**Permit #638 - 6 Oxford St Ext**

I am in the process of reviewing your application for demolition and renovation at 6 Oxford St, but there a couple issues I need to touch base with you about. First, the project cannot qualify for fast-track because it involves exterior demolition and is therefore not purely a renovation "within the existing shell."

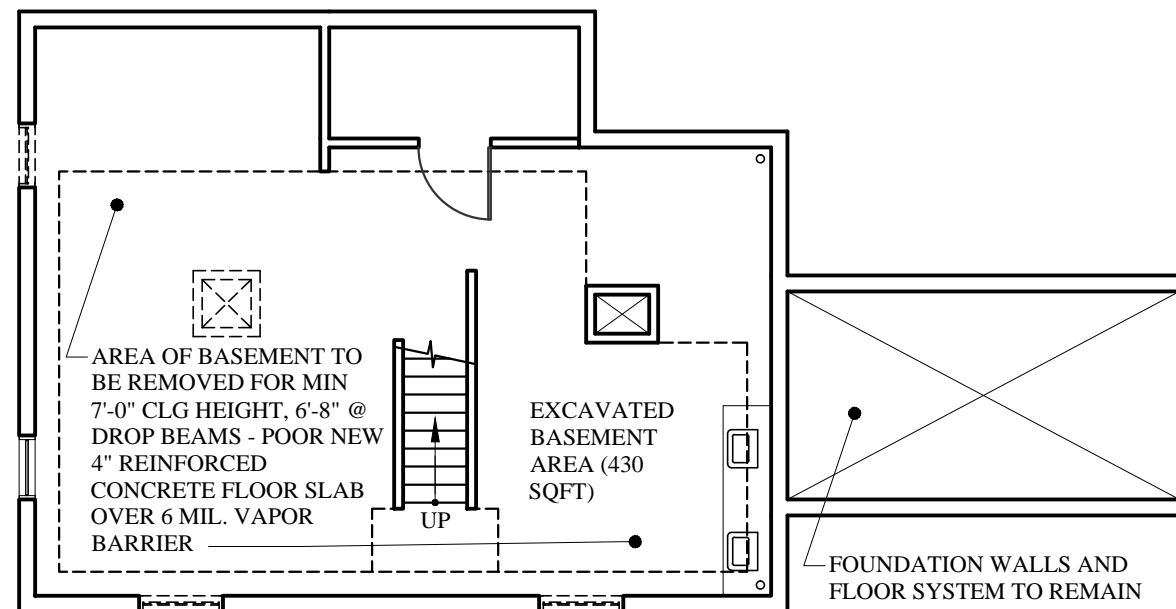
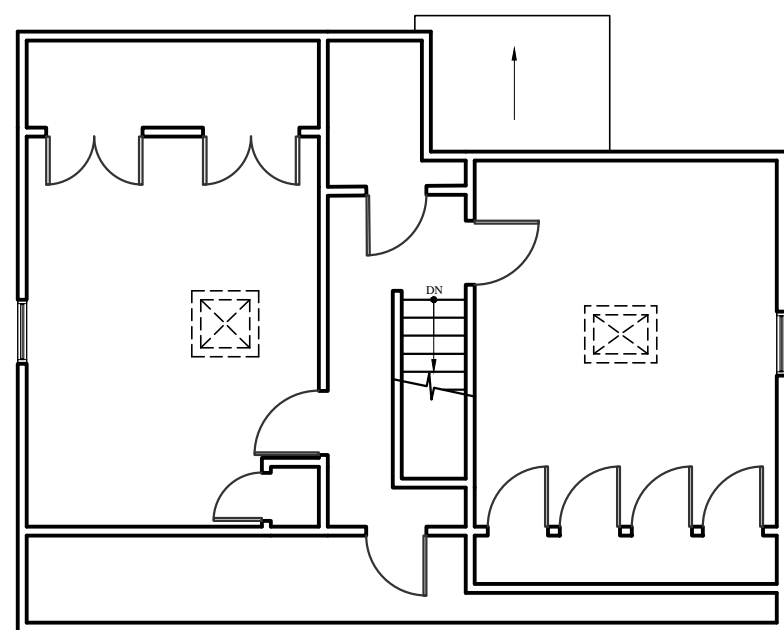
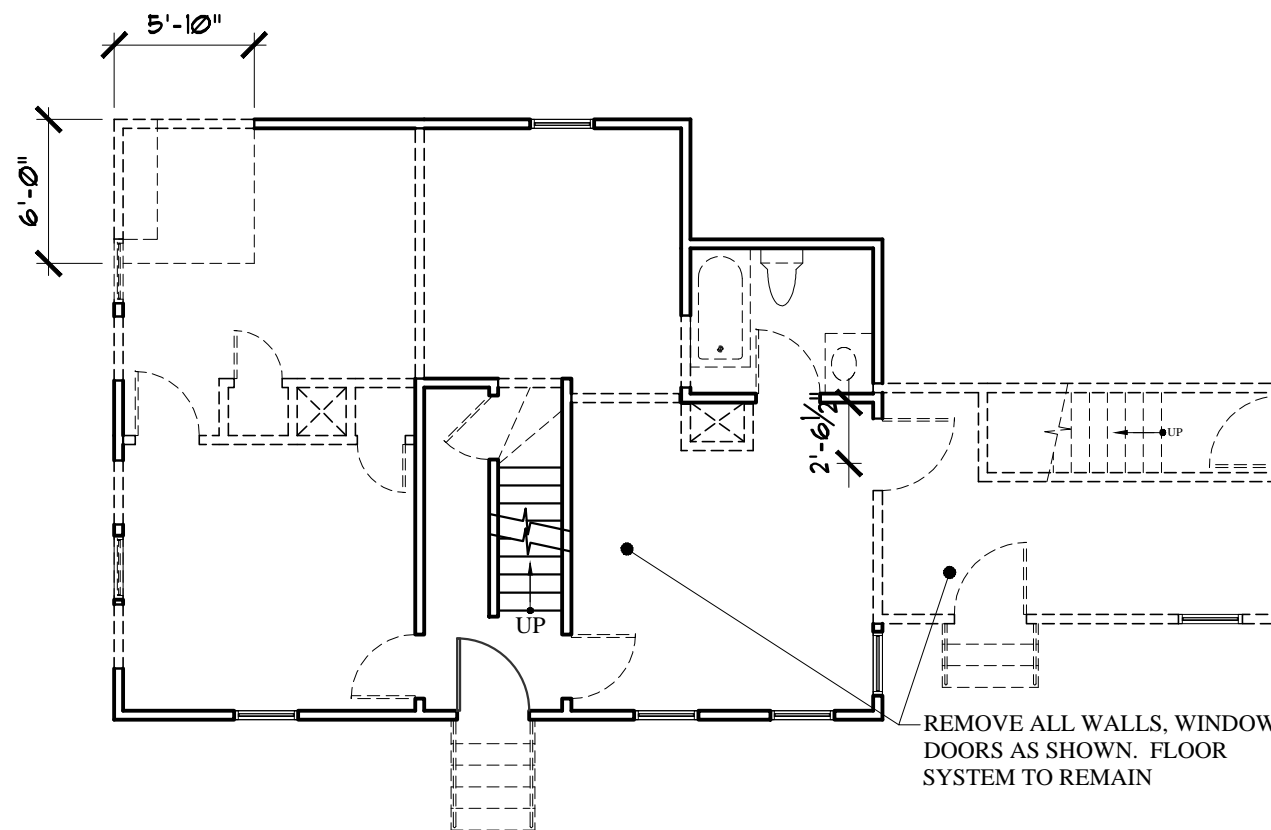
Second, I wanted to confirm that the proposal is to demolish the rear addition (which contained an enclosed stairway) and replace it with an exterior open stairway? This may be a concern under the building code requirements, but we need more information in order to fully assess the application, including:

Per the building permit #638 submitted for 6 Oxford Street, I would like to exclude the removal of the rear section at this time and only include the renovations within the existing structure, so as to qualify for fast-track approval.

The exterior work portion of the original application (tearing off the back section of the building) shall be split out and re-submitted as a separate/secondary application for permit.
